**REQUEST**

Current Zoning: N1-A (Neighborhood 1)  
Proposed Zoning: R-8MF(CD) (Multifamily Residential, Conditional)

Approximately 14.46 located west of N Tryon Street, east of Morehead Road, and north of Floyd Smith Office Park Drive.

The petition proposes to develop a vacant parcel with 70 single family attached residential units and accessory uses.

SCHEMATIC SITE PLAN

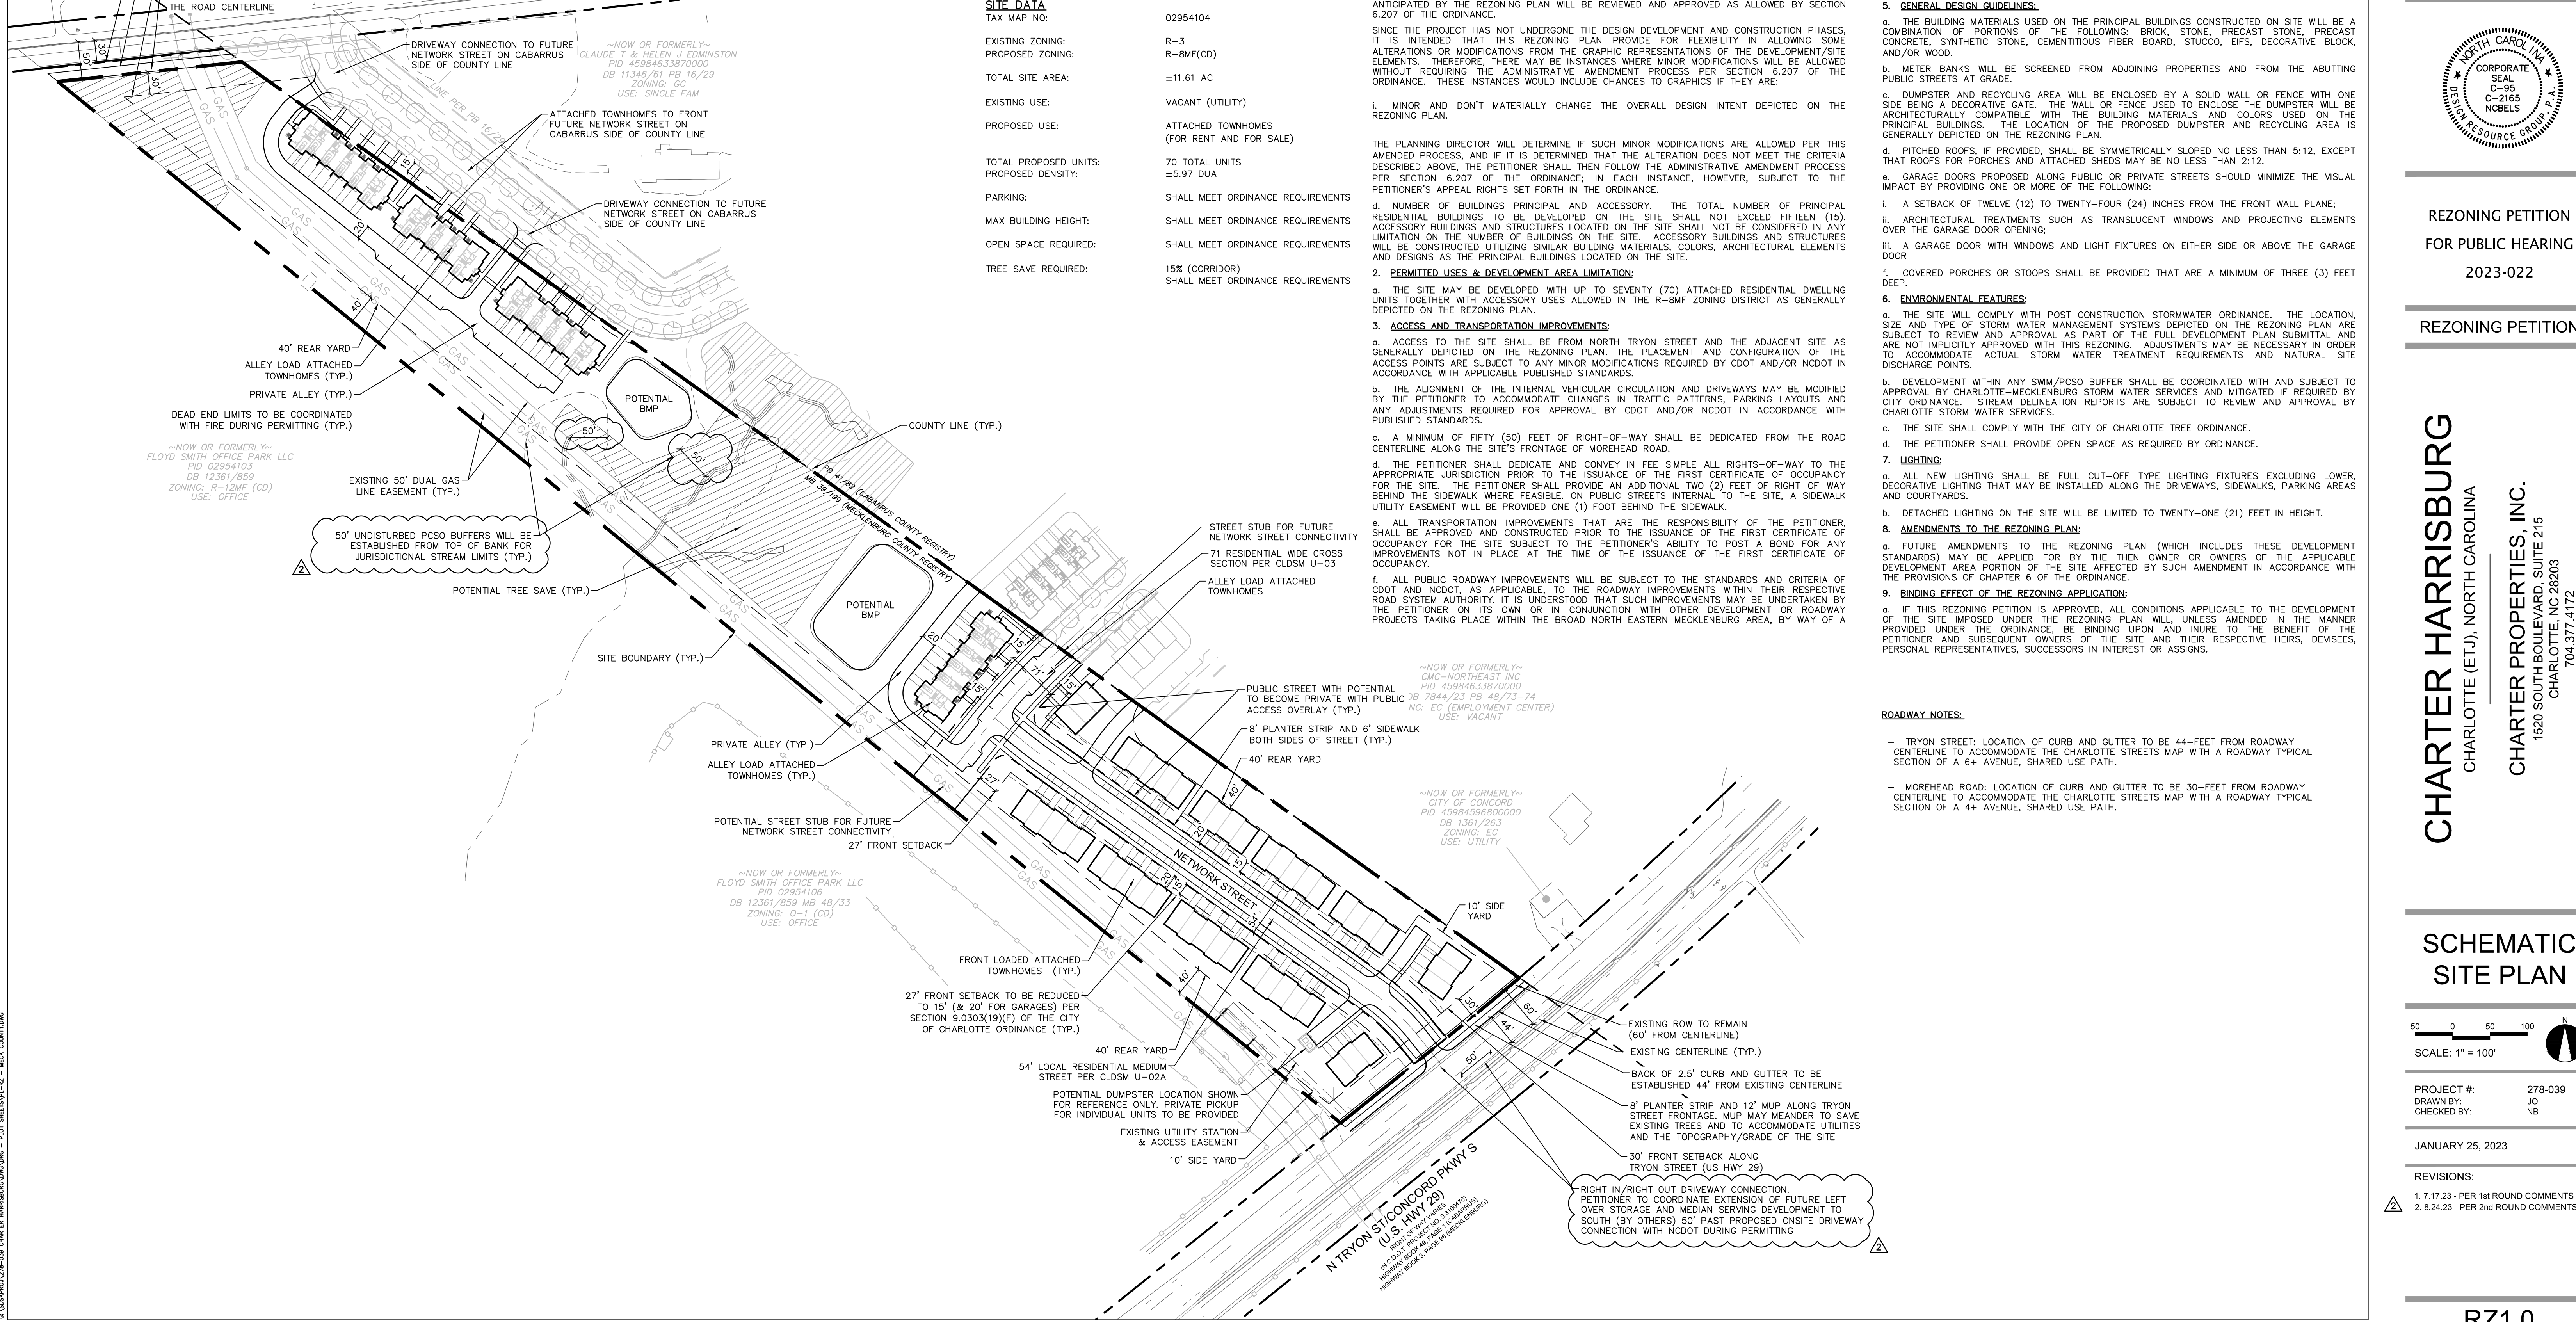
- The site is located on a State-maintained, major thoroughfare. A Traffic Impact Study (TIS) is not required for this site due to the site generating less than 2500 daily trips. Site plan and/or conditional note revisions are needed to commit to removing the access point on Tryon in coordination with NCDOT. Further details are listed below.

1. Revise site plan and conditional notes to commit to removing the Tryon Street access point in coordination with NCDOT. **OUTSTANDING**
